Subject: RE: 21/62/091239/W 410 & 412 Birkby Road

Thank you. I note that the number 412 has diminished in size and has moved. However, as previously these comments focus upon 410., although there may well be consequences to no.412. We have avoided comments on design and beauty.

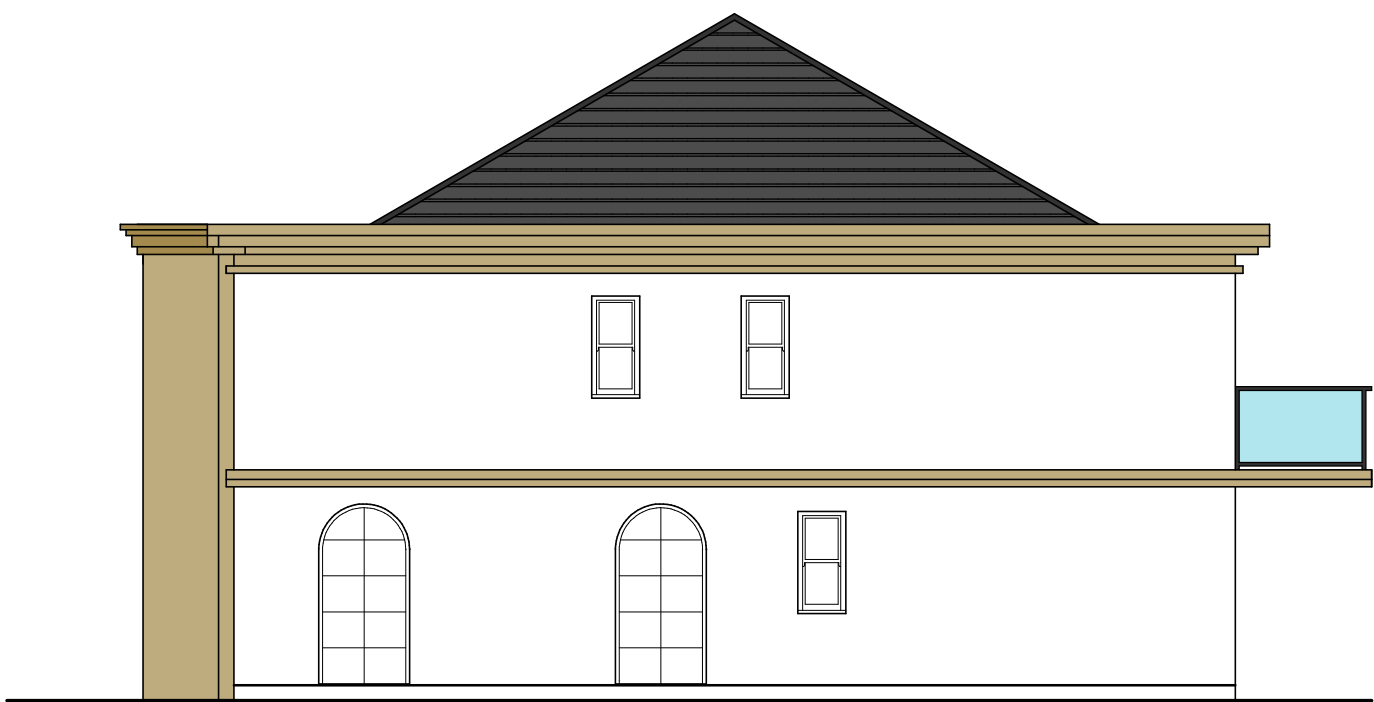
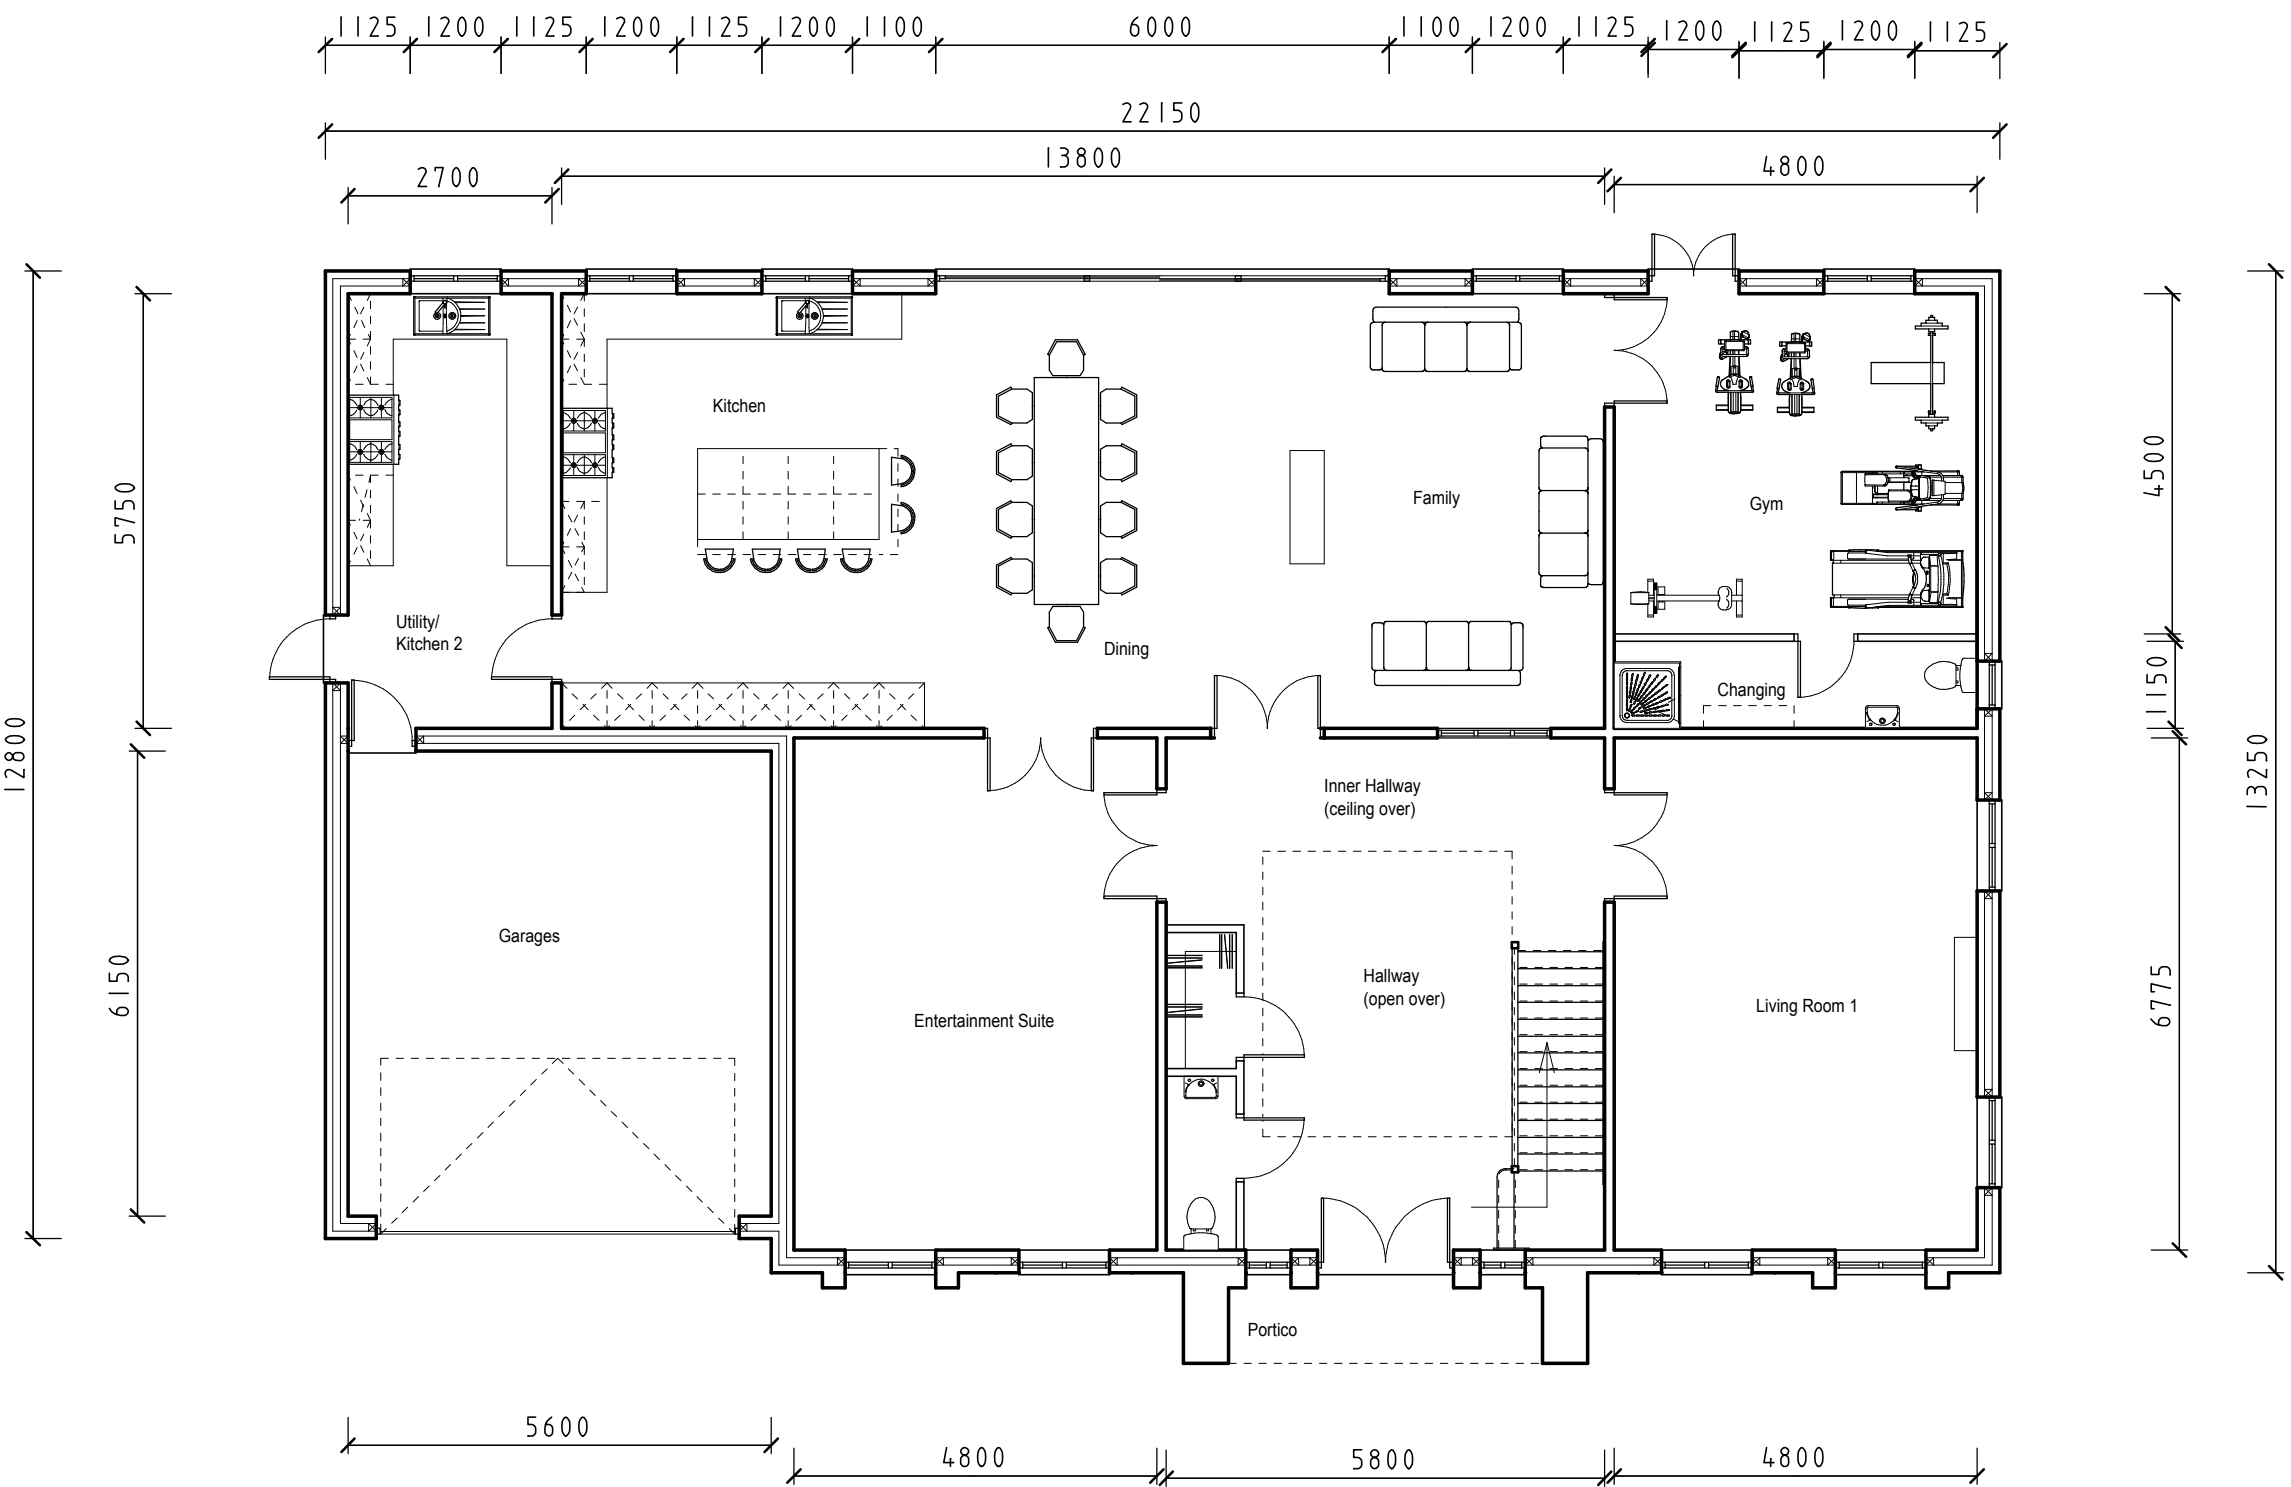
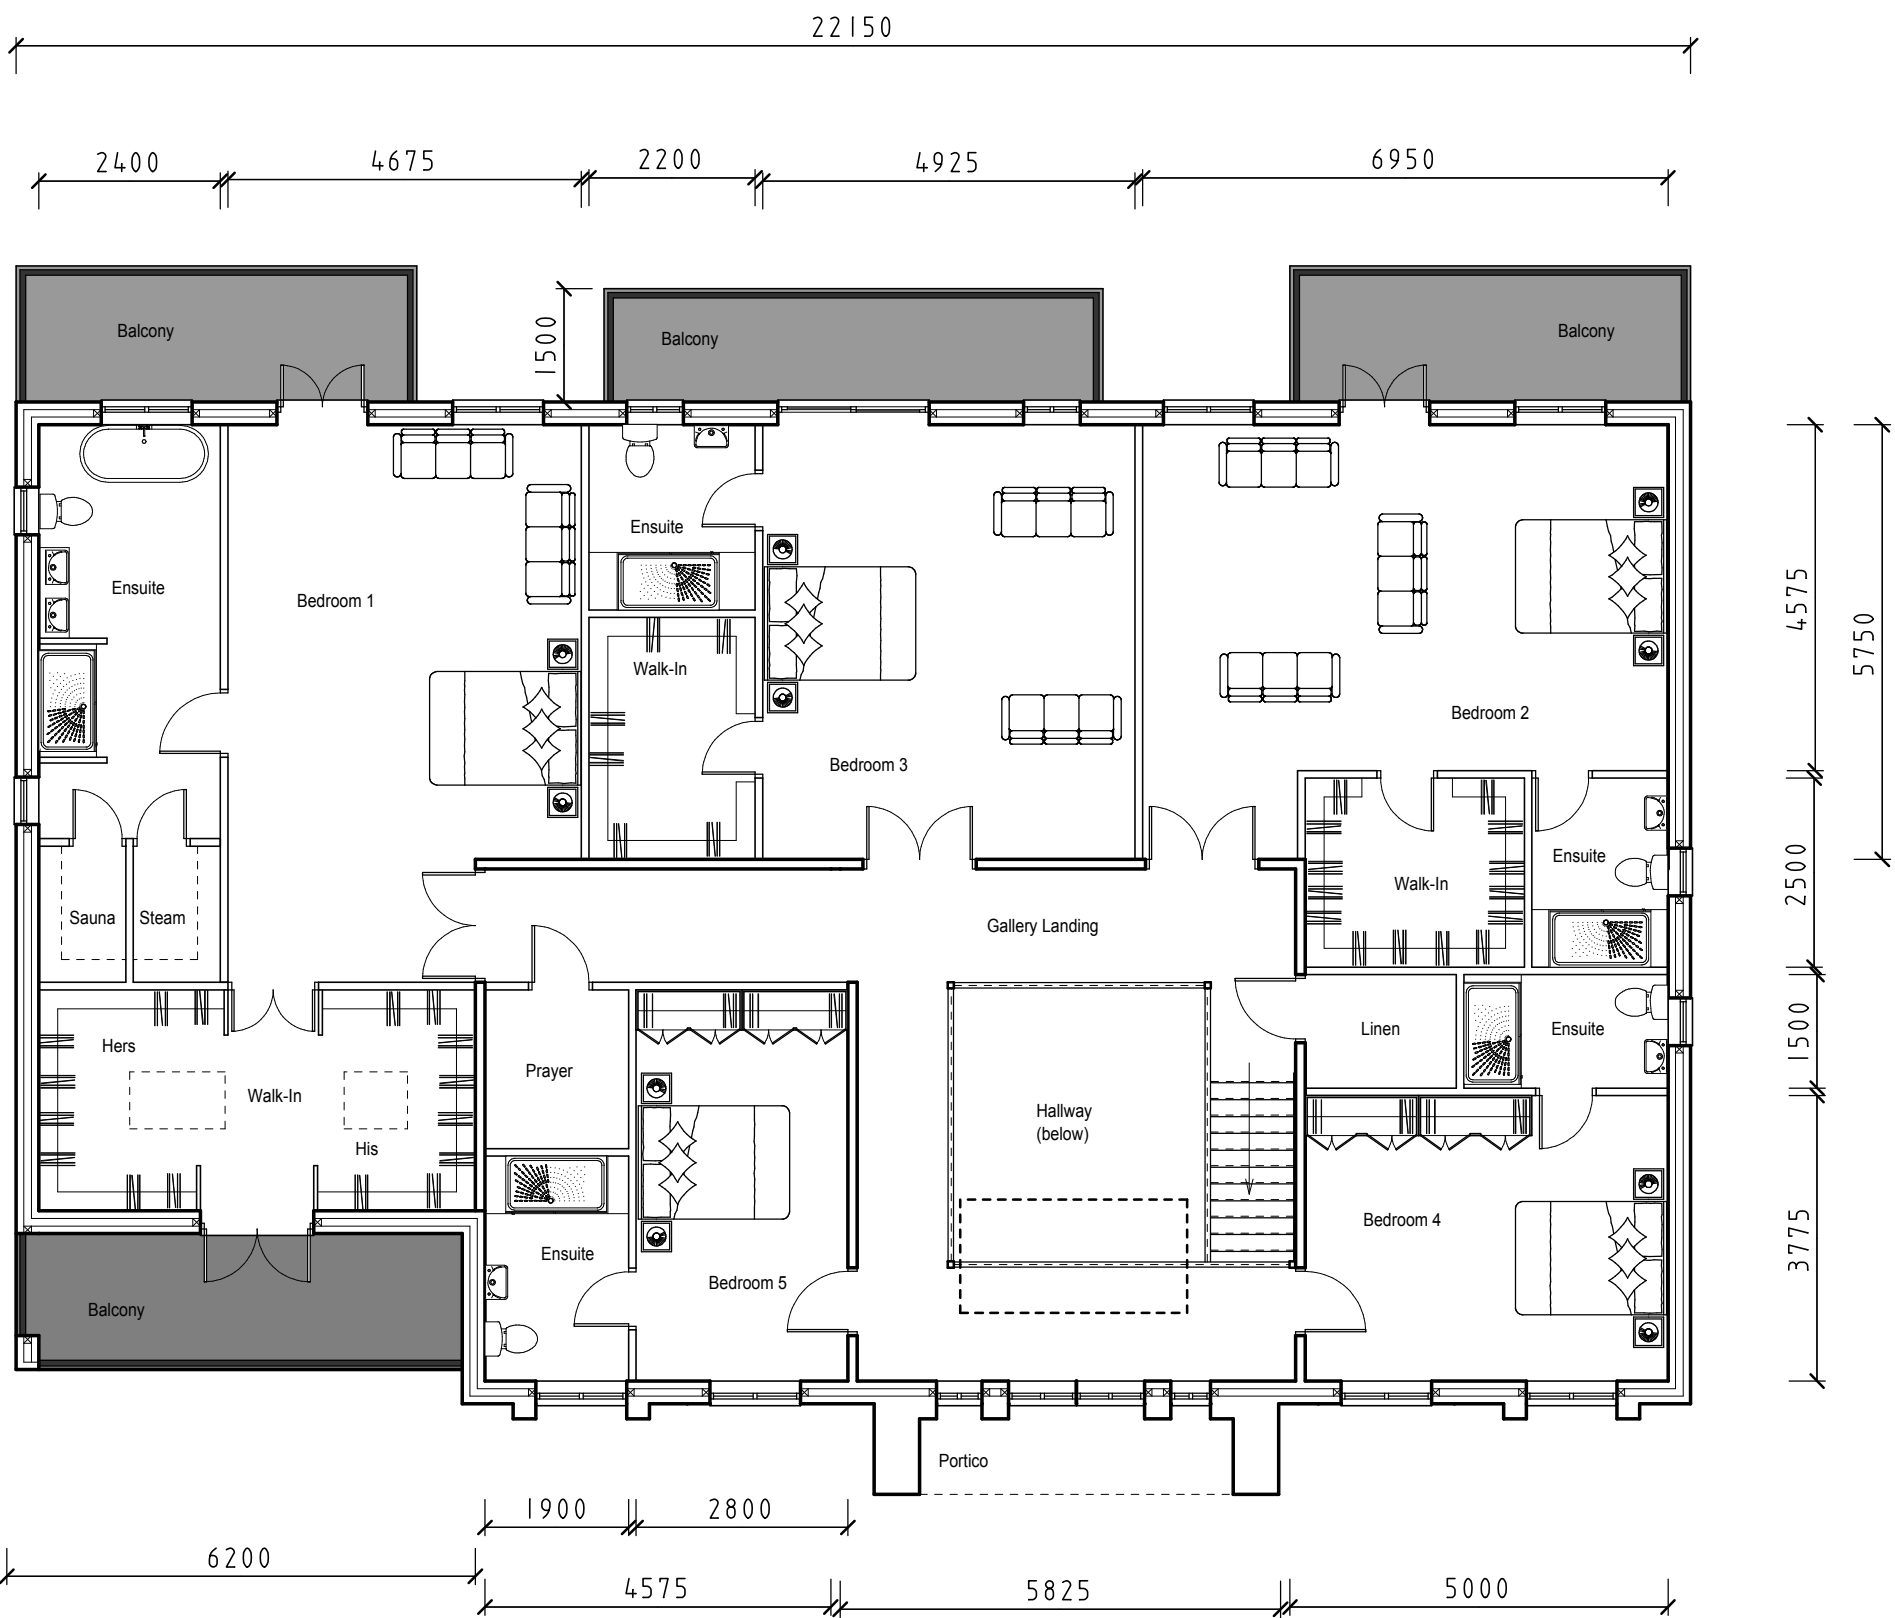
From the site plans and elevations for number 410 however, we note that there are still issues of overlooking and privacy for the Bishop's House, and in particular the garden. I cannot therefore state that the amendments satisfy the concerns over amenity and overlooking which were clearly a consideration when the existing bungalow was approved and the treatment to the eastern elevation in particular.

On this there remain two windows on the eastern elevation that overlook the properties to the east and in particular the balconies at first floor level. These may be not an issue so much in the summer when the trees are broadly full leaf, but the trees and ground level bushes appear to have been subject to judicious thinning already. During the winter, spring/early summer and autumn there are concerns of overlooking. This is exacerbated by the difference in height between the two.

There is a desire therefore for the ground floor windows on the eastern boundary to be removed or obscure glazed, along with the removal of the external balconies at the first floor level on the northern (rear) elevation. As suggested previously Juliet type balconies may be appropriate. These are considered to be reasonable compromises, the preference would be for the replacement dwelling to replicate the same treatments as is present on site as existing.
